Ref 2241.corr.RVBC260619

2241 Winkley Hall Farm, Whalley Road, Hurst Green , BB7 9PN

Application references 3/2026/0094 and 0095

B East Facing Section B
Scale: 1:50

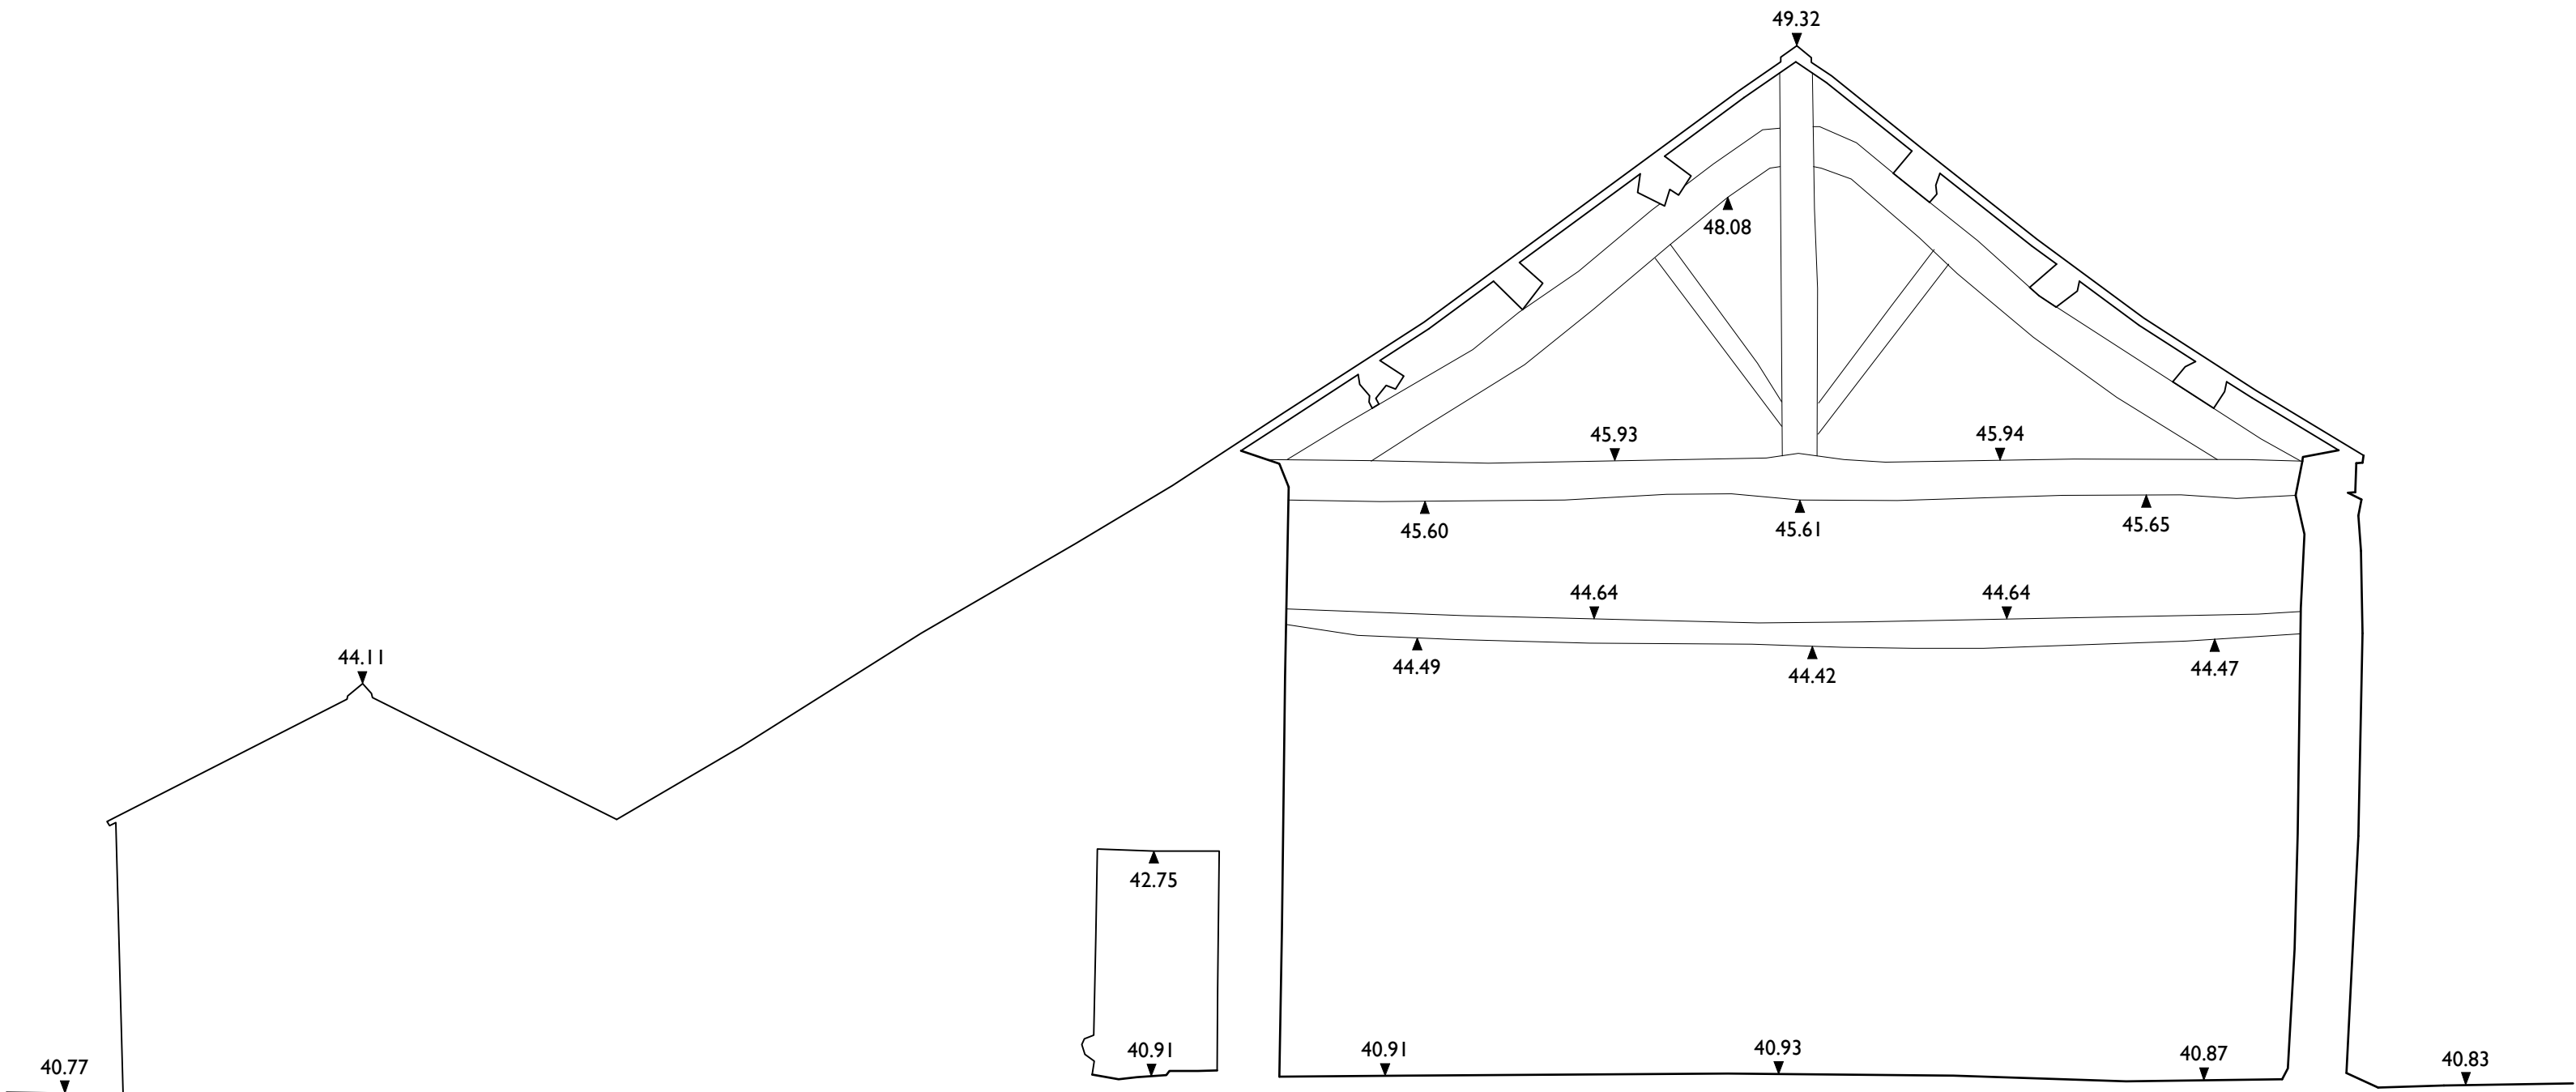
9. De-frassing is to be removed from the revised structural report as part of an alternative repair/treatment strategy.
10. We assume this point related to the low-level beam in the Main Barn – now illustrated on sections B (107 existing & 117 proposed). This beam is not a tie beam and also plays no part in supporting the truss as assumed by Growth Lancs. The beam would need to be removed to accommodate the proposals and provide access to the relocated bed no.1 (to suit point 7) from the main stair. We do not believe omitting a bedroom is an option given the scale of this barn. Providing an alternative access to the bedroom via the study/library deck has also not been considered due to restricted headroom.

name
Proposed 'barn 2' ground/first floor

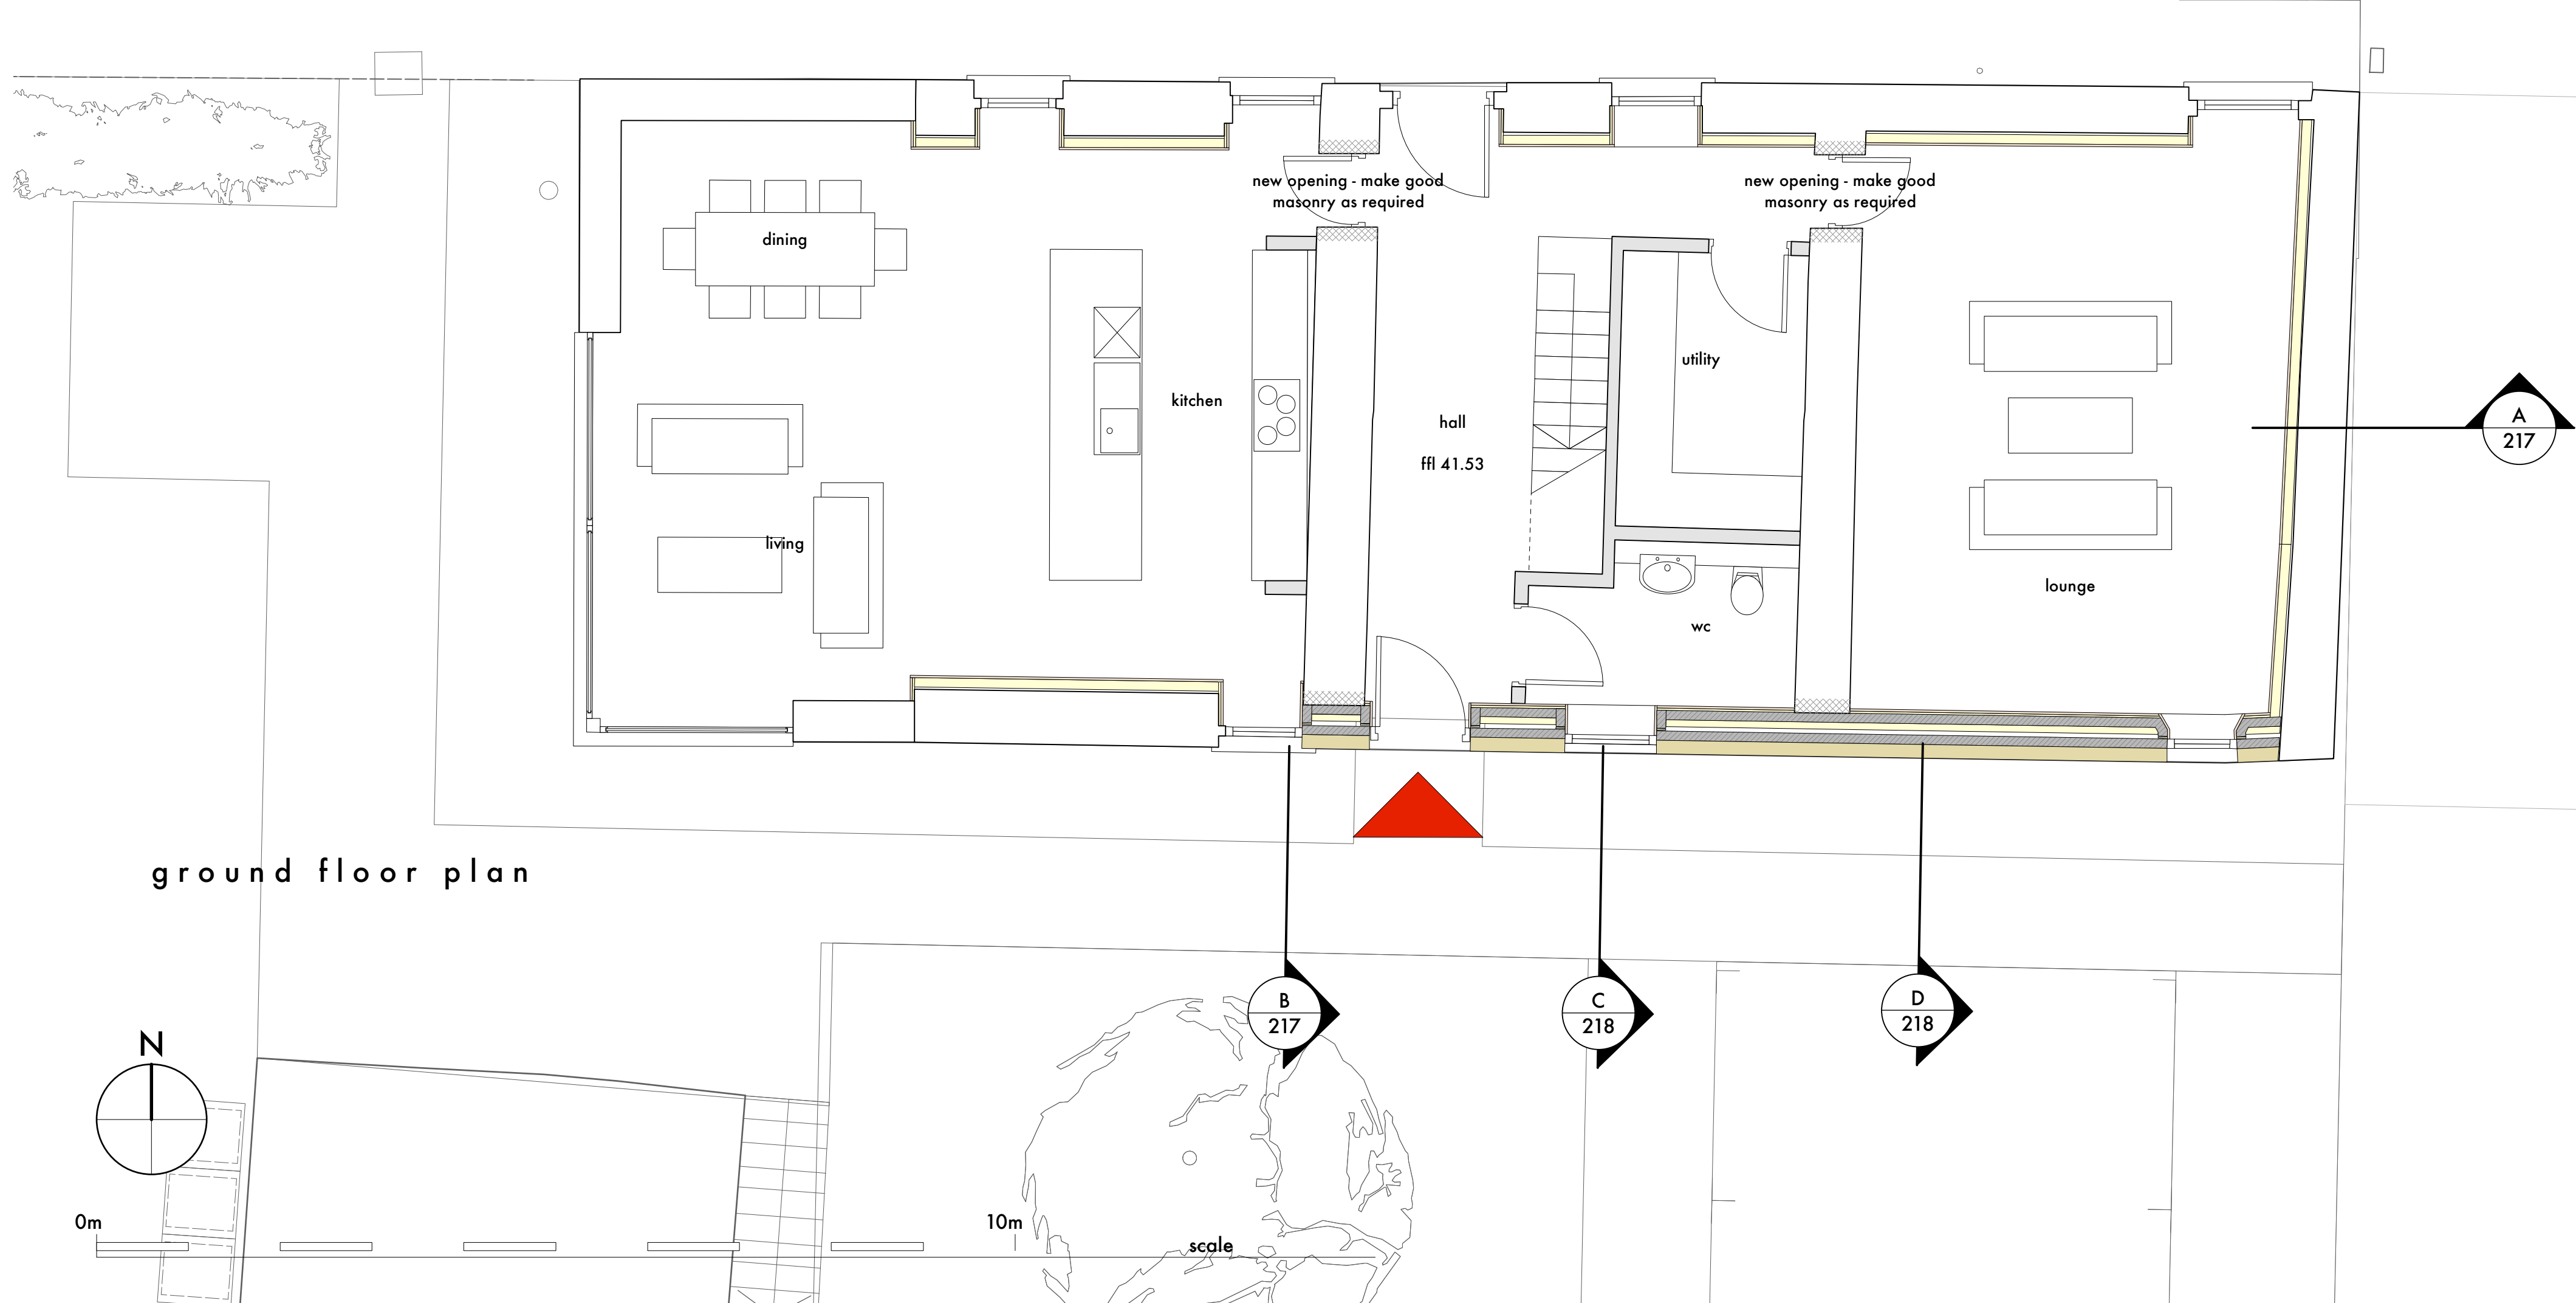
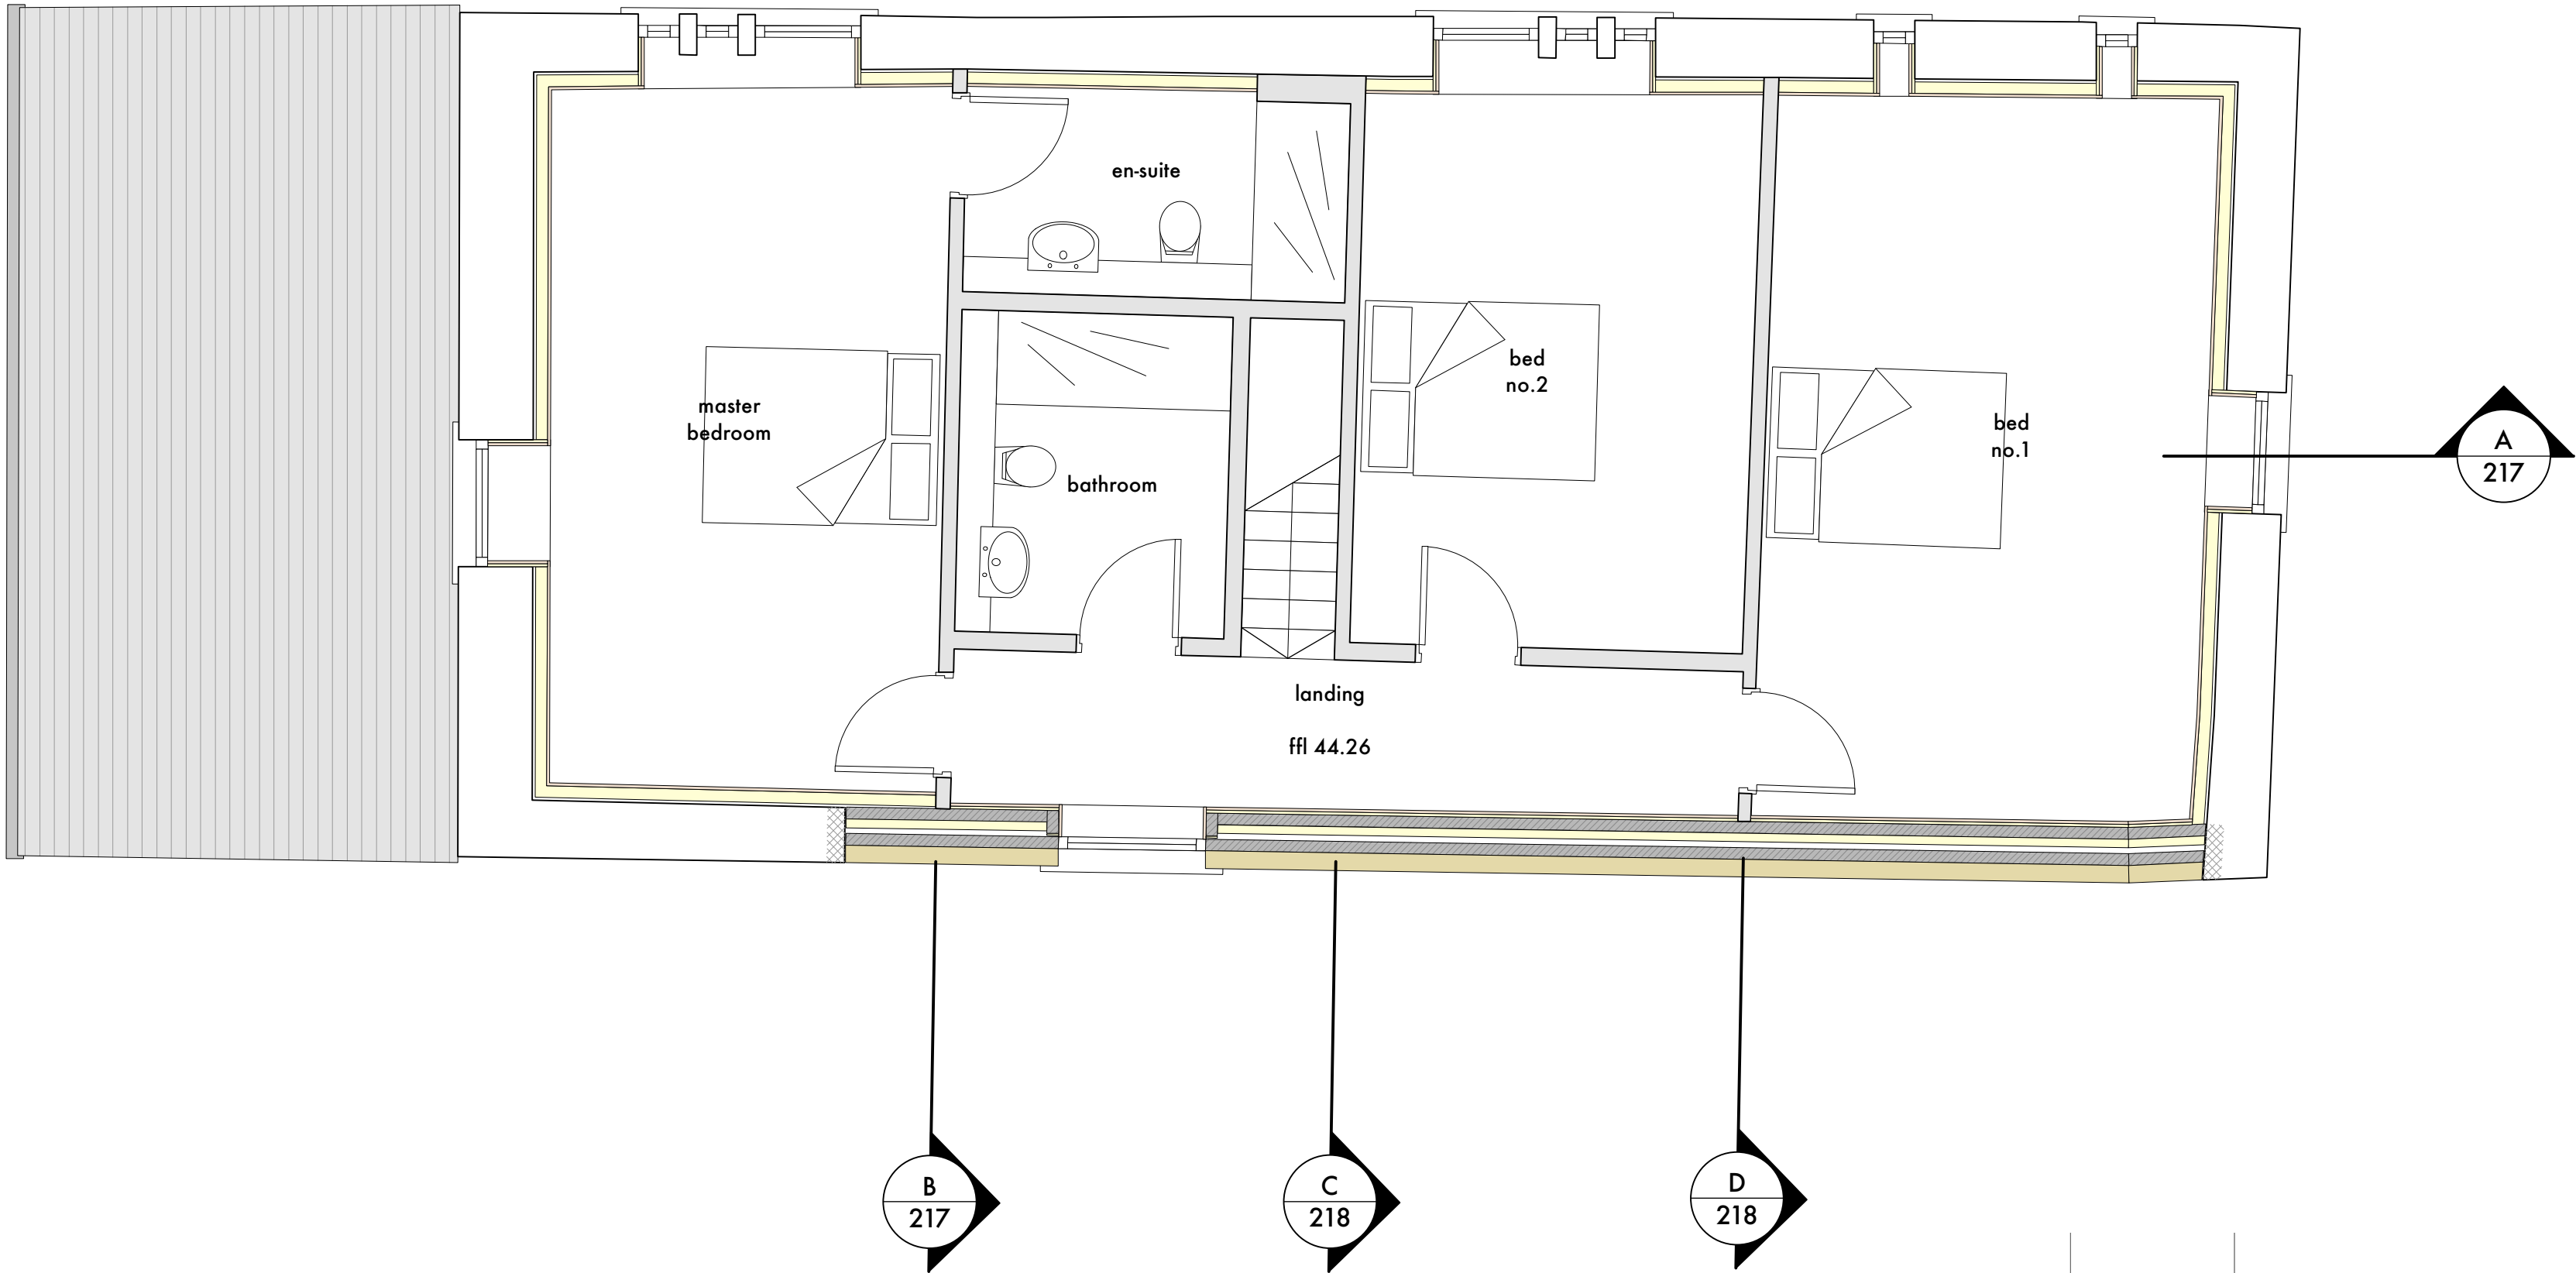
4. Extent of wall re-building illustrated - predominantly to Barn 2 on the respective plans, elevations, sections (211-212 & 215-218). Proposed specification included on the section details drawing (220).
